November 09, 2023

Re: Farolito Senior Community - Mixed-use Multifamily

Is responding to DFT comments dated October 18th, 2023. DFT comments are shown in **Red**
and Responses are shown in **Orange**.

LP501

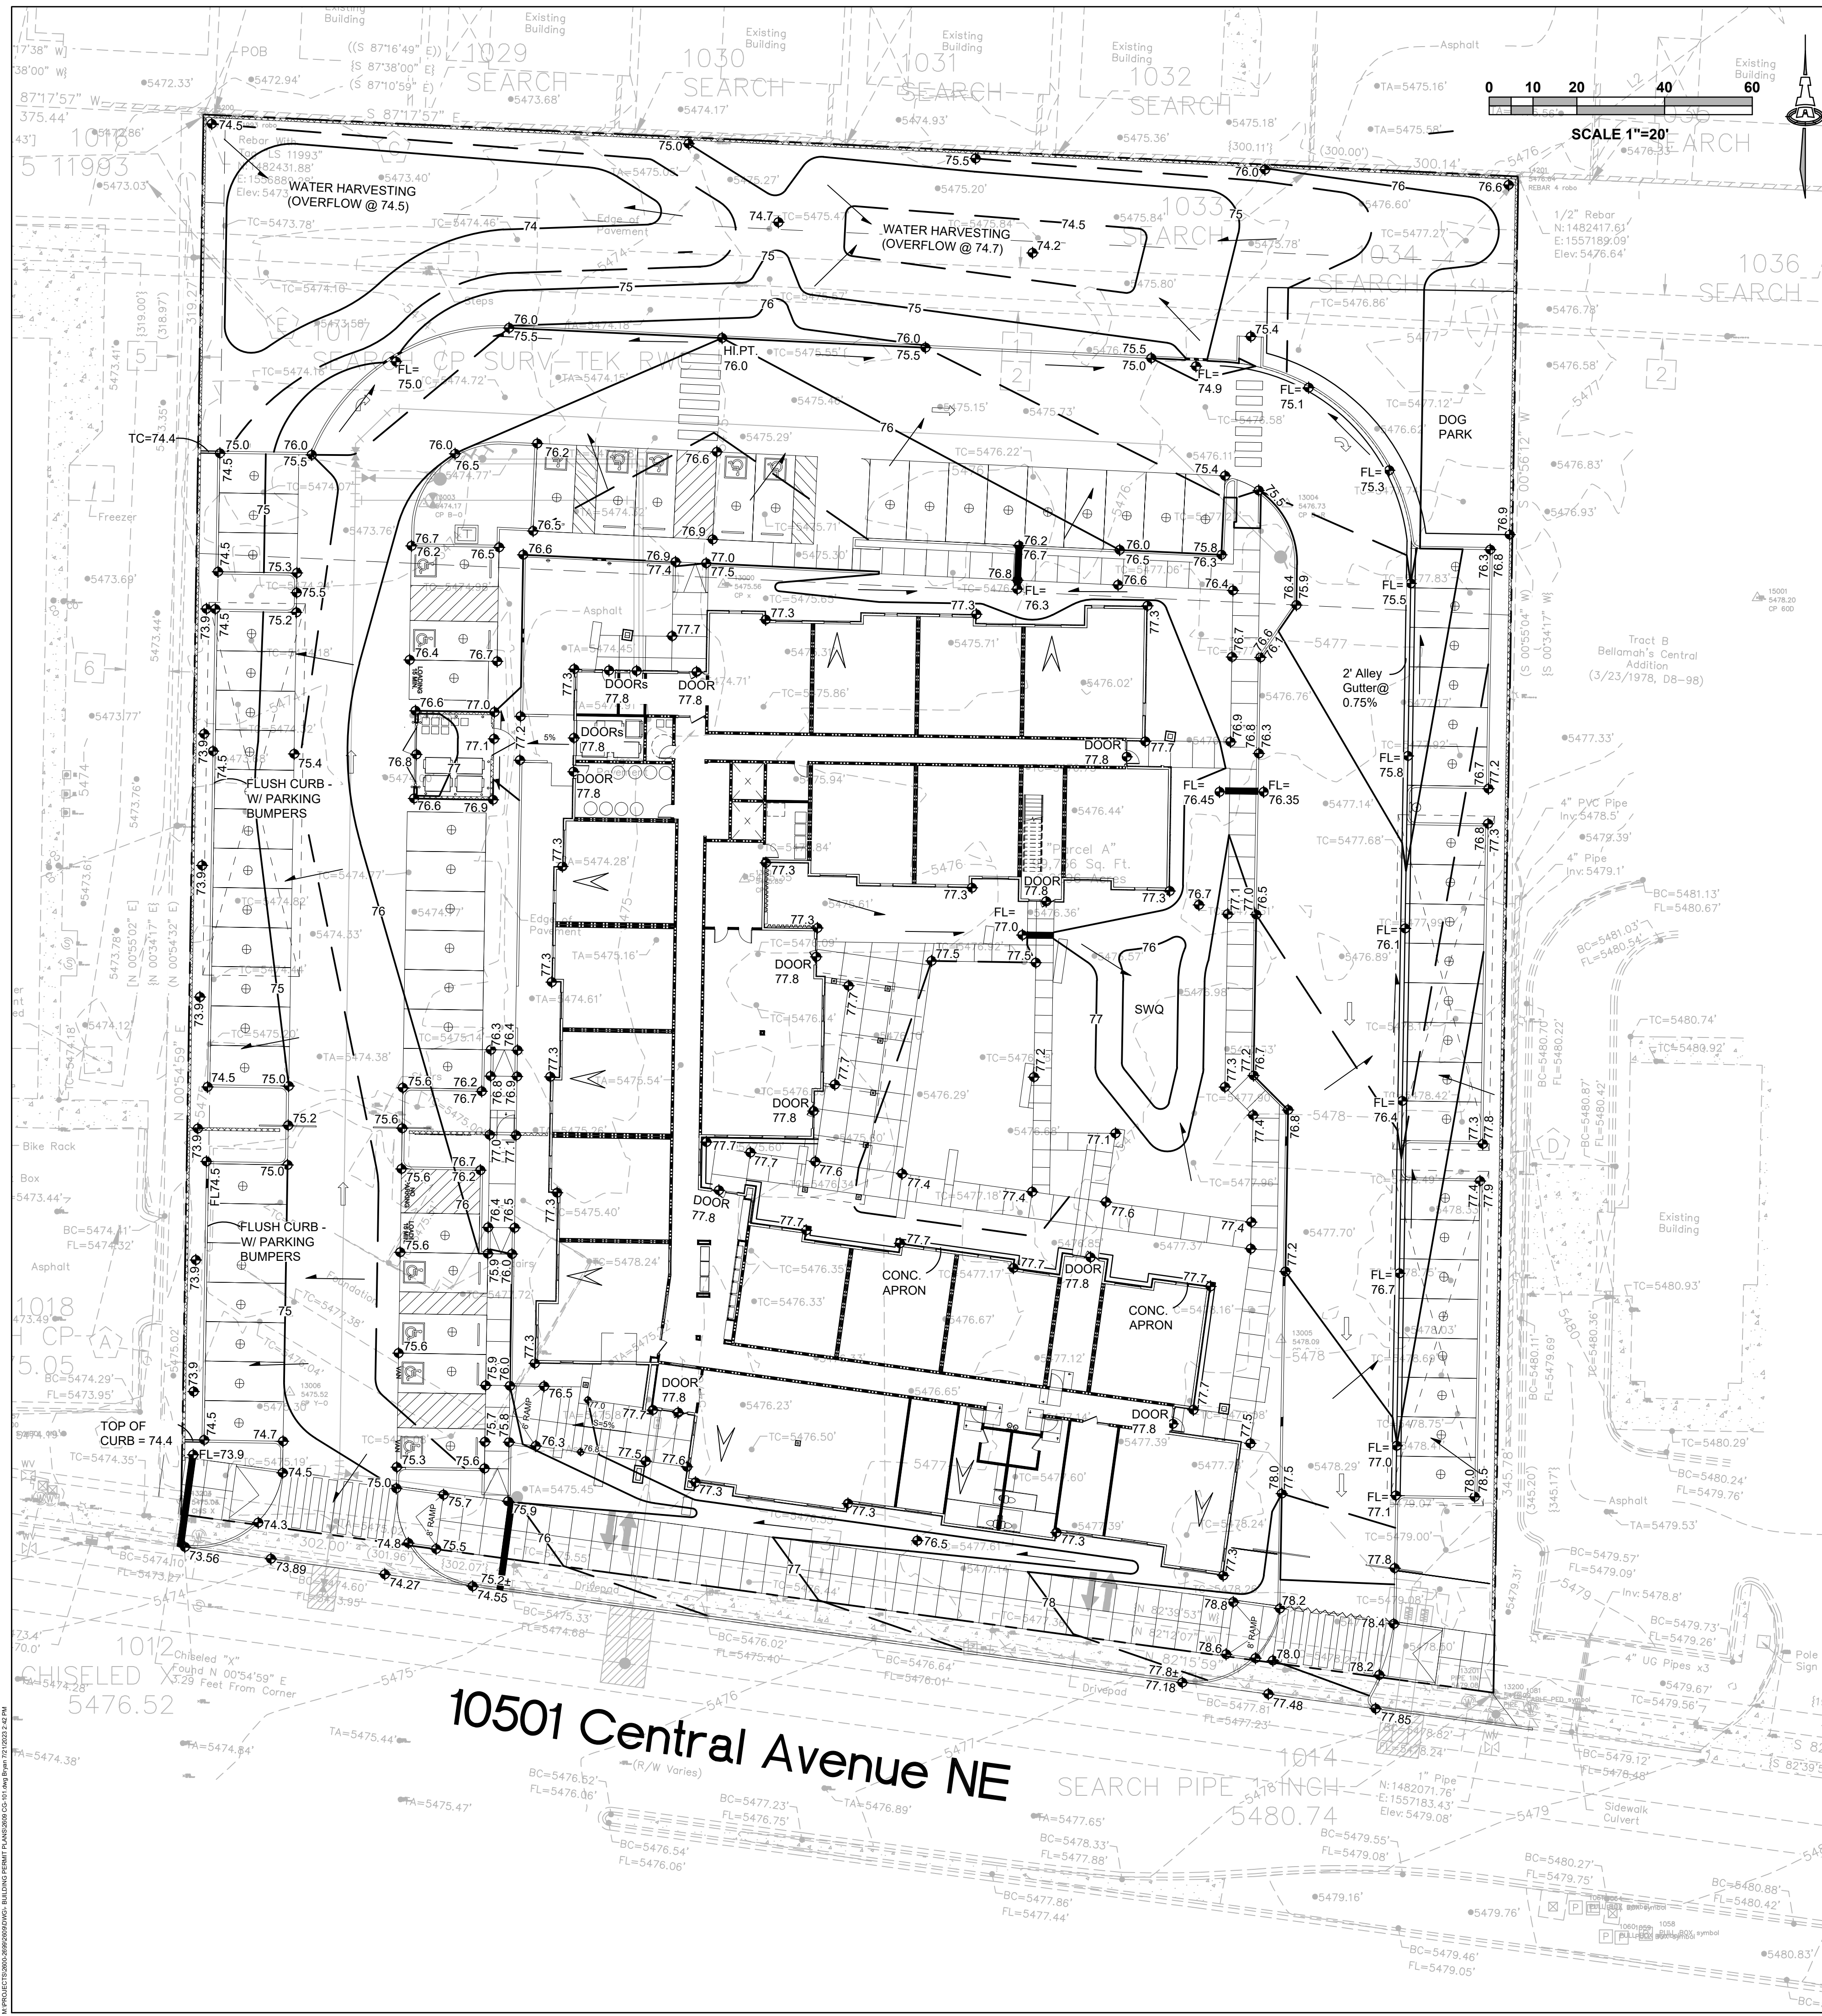
- Ensuring the use of native and/or adapted, low water use or xeric species and regionally appropriate, sustainable design and maintenance techniques to conserve water resources. Please provide plant quantities, mature size and level of water consumption on your plant legend. Adding a separate sheet for this so that everything is legible, see LP501, DFT
